July 9, 1987

RE: BUILDING PERMIT FOR 601(A) FOUR HILLS ROAD, SE (BP87-52) (L-23/D6A)

City/County Floodplain Administrator

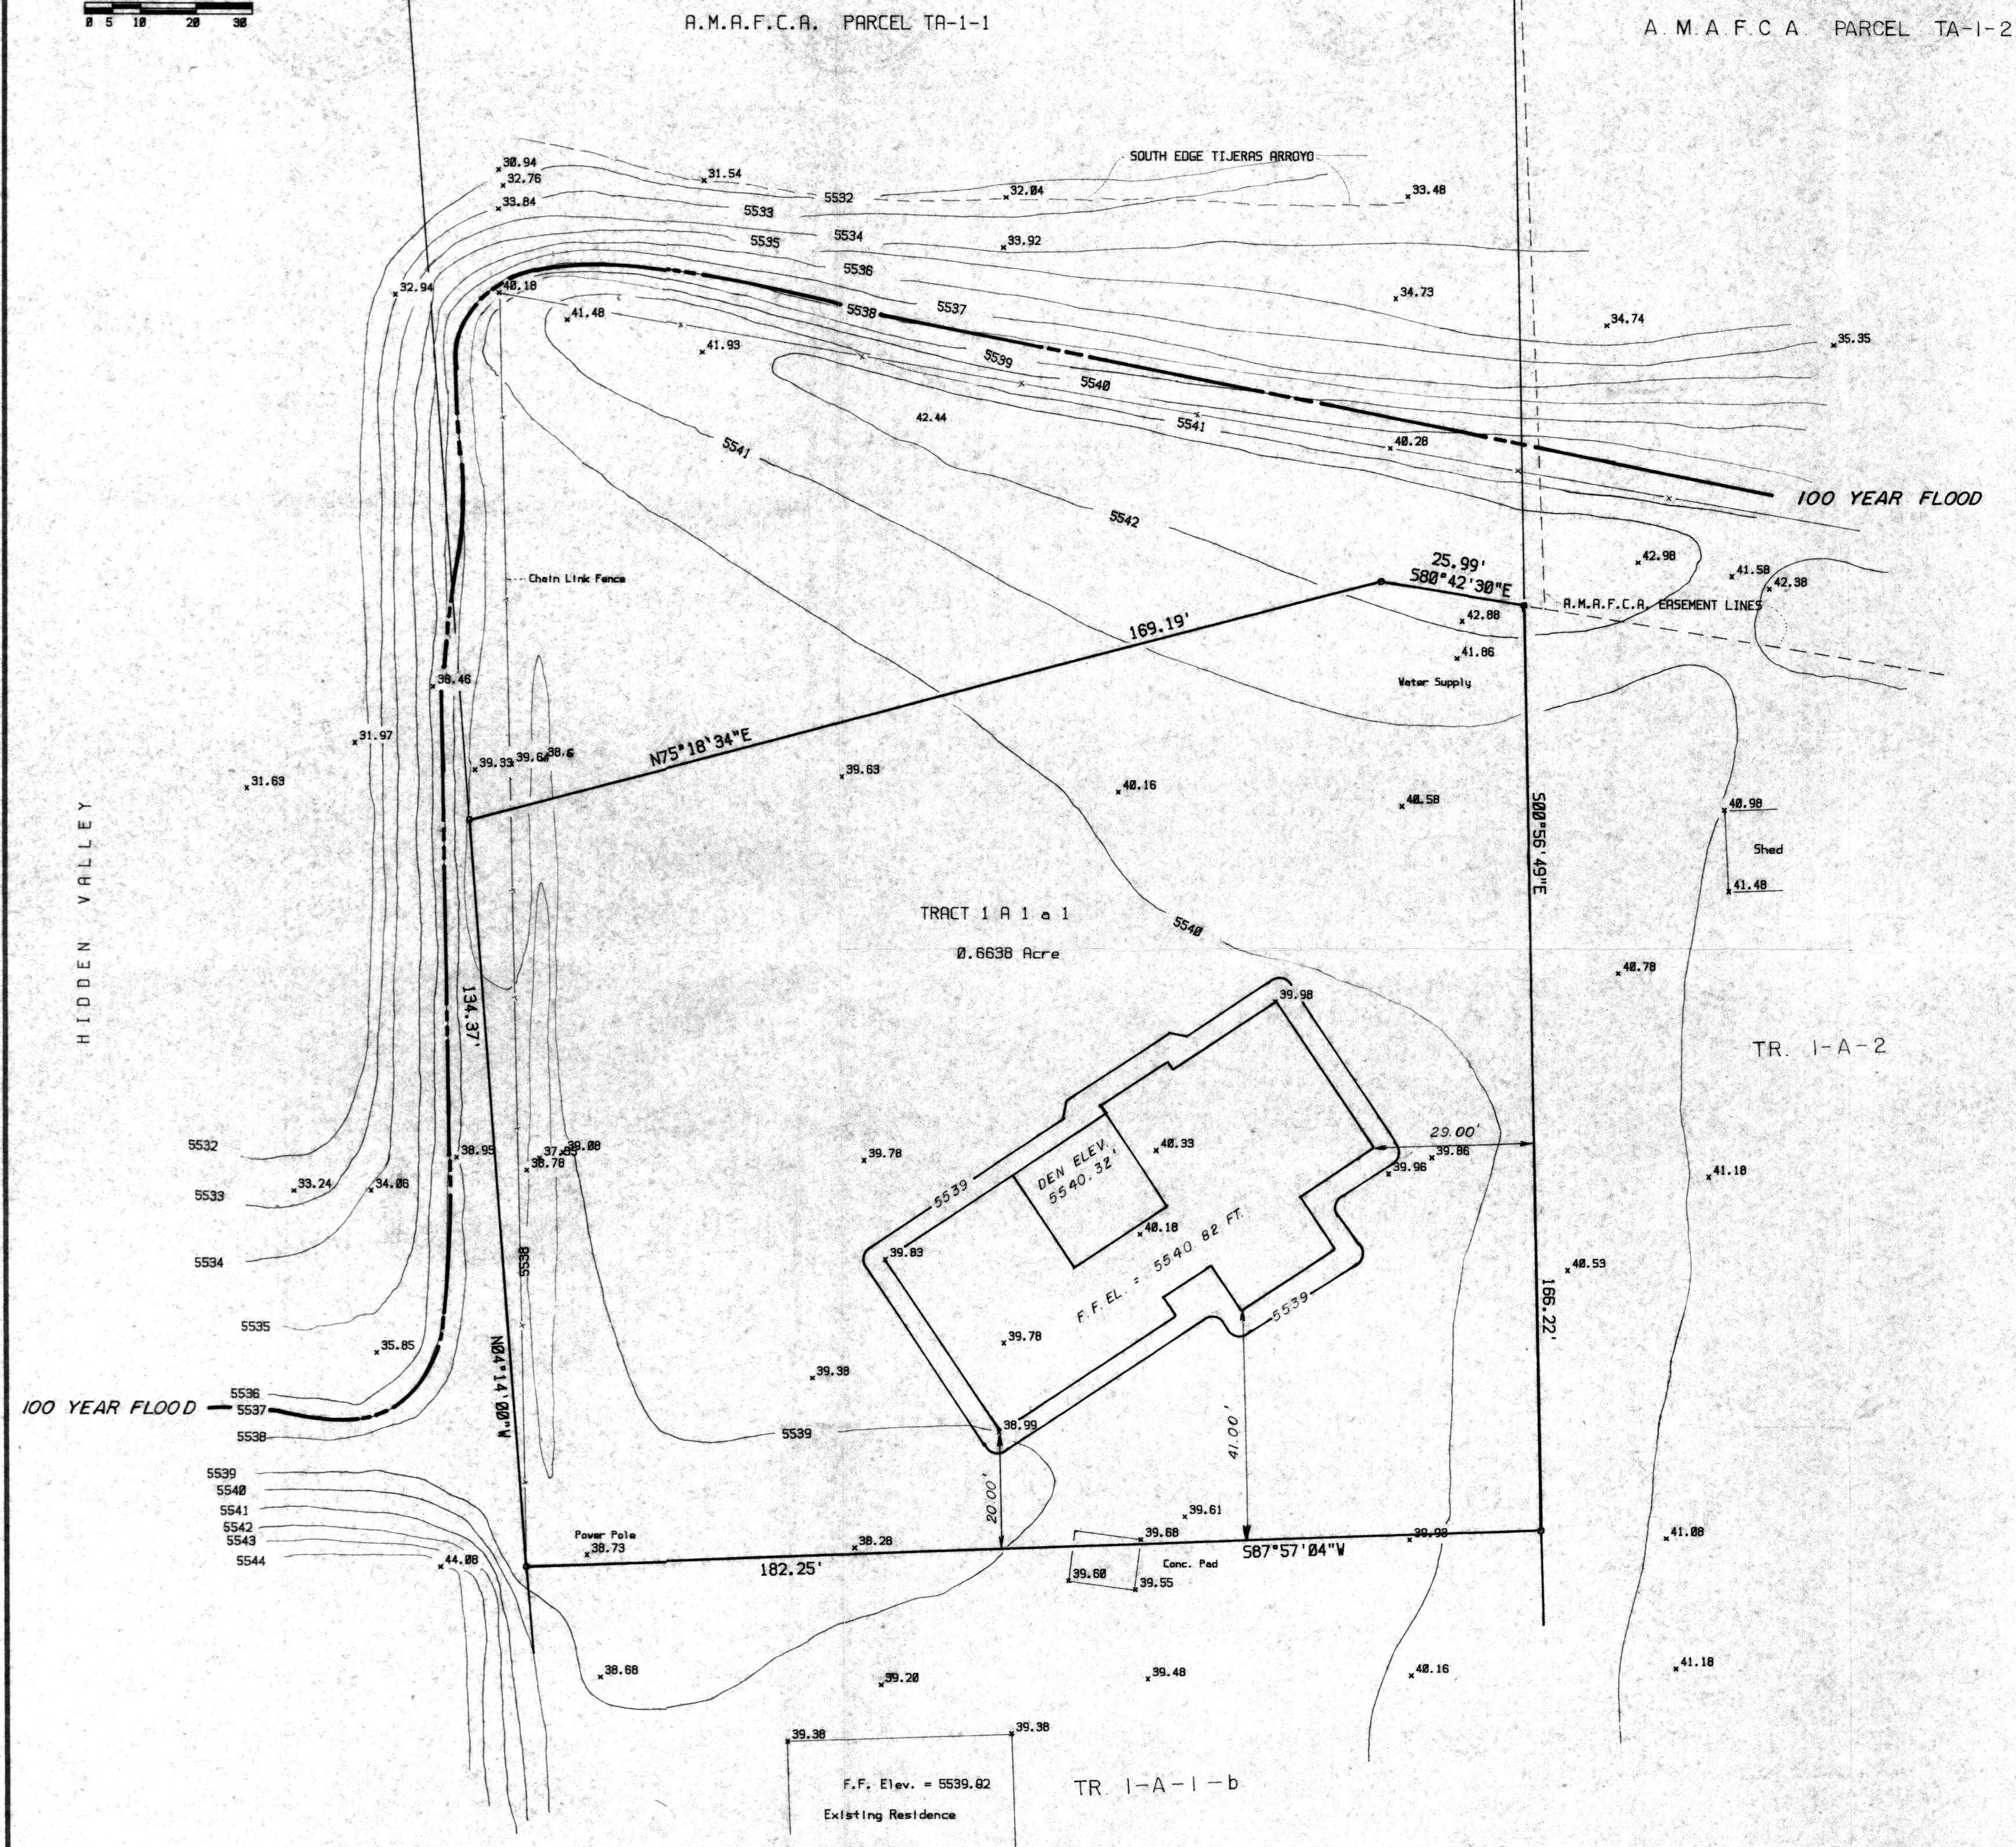
- 1. A drainage plan by a professional engineer indicating the following
 - A. Plan showing existing contours for the lot.
 - B. Proposed finish floor elevation.
 - C. 100 year floodplain water surface at the residence.
 - D. The house should not encroach into the Tijeras Arroyo floodway.
- 2. Written documentation that you understand the court settlement between AMAFCA and Mr. Donald Veretto, October 1981.
- 3. Please show the location of the house on a plat. Please show the AMAFCA easement.

Please submit the final finish floor elevation to mean sea level. The above information will be sufficient for certification.

I have reviewed the above referenced plan and forward the following comment. Please address if the house is being placed in the floodway. The Floodplain Ordinance has certain requirements if the house is placed in the floodway and not in the shallow flooding area.

In reference to your letter dated August 14, 1987 the proposed building site is not in the 100 year floodway. It is, however, in a shallow flooding area. Note that the finish floor elevation is one (1) foot above the nearby residence.
